Deadline 3 – South Ribble Borough Council Response to Examining Authority’s Written Questions and Requests for information ExQ1)

Planning Inspectorate Ref: EN020028

Morgan and Morecambe Offshore Wind Farms Transmission Assets

**Drawing Number:**  
BP-GBR-MORG-REG-0185

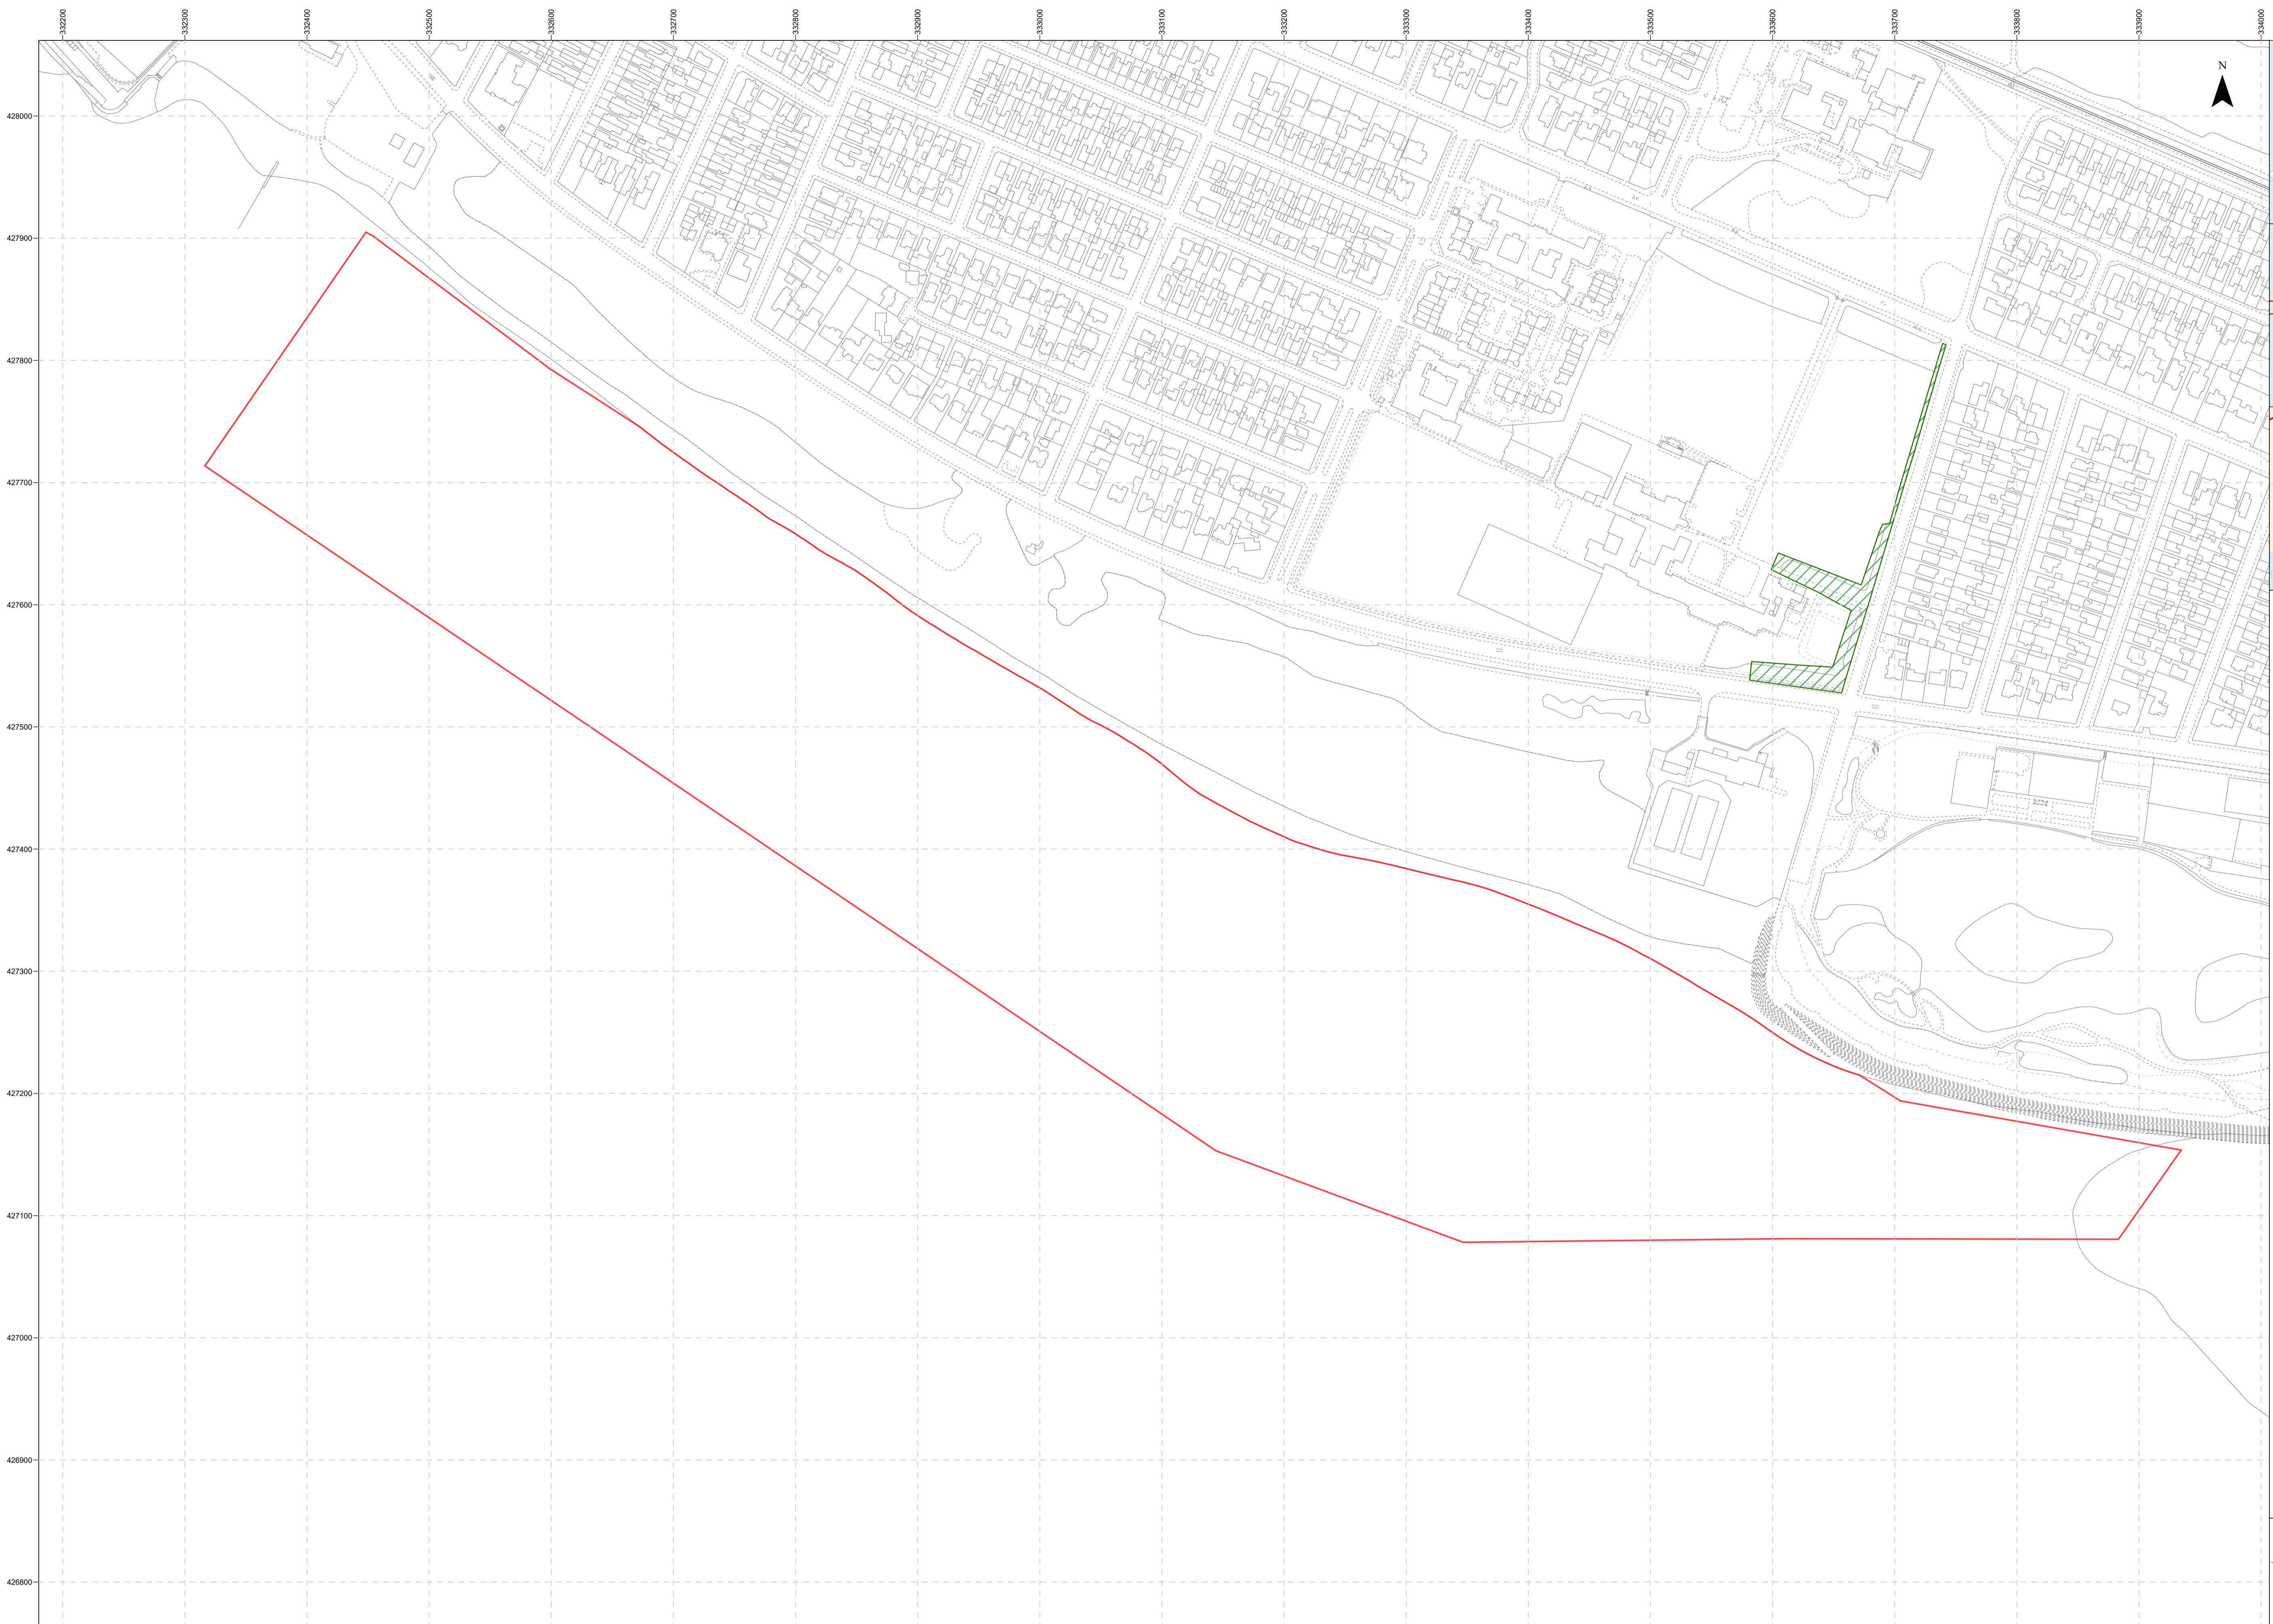
It is noted that construction access 19A19B and cable corridor 34A34B are shown on BP-GBR-MORG-REG-0185 (APP-167) by ref MGMC141 as running through a protected woodland, but otherwise there do not appear to be any other trees that would warrant protection aside from the existing within South Ribble.
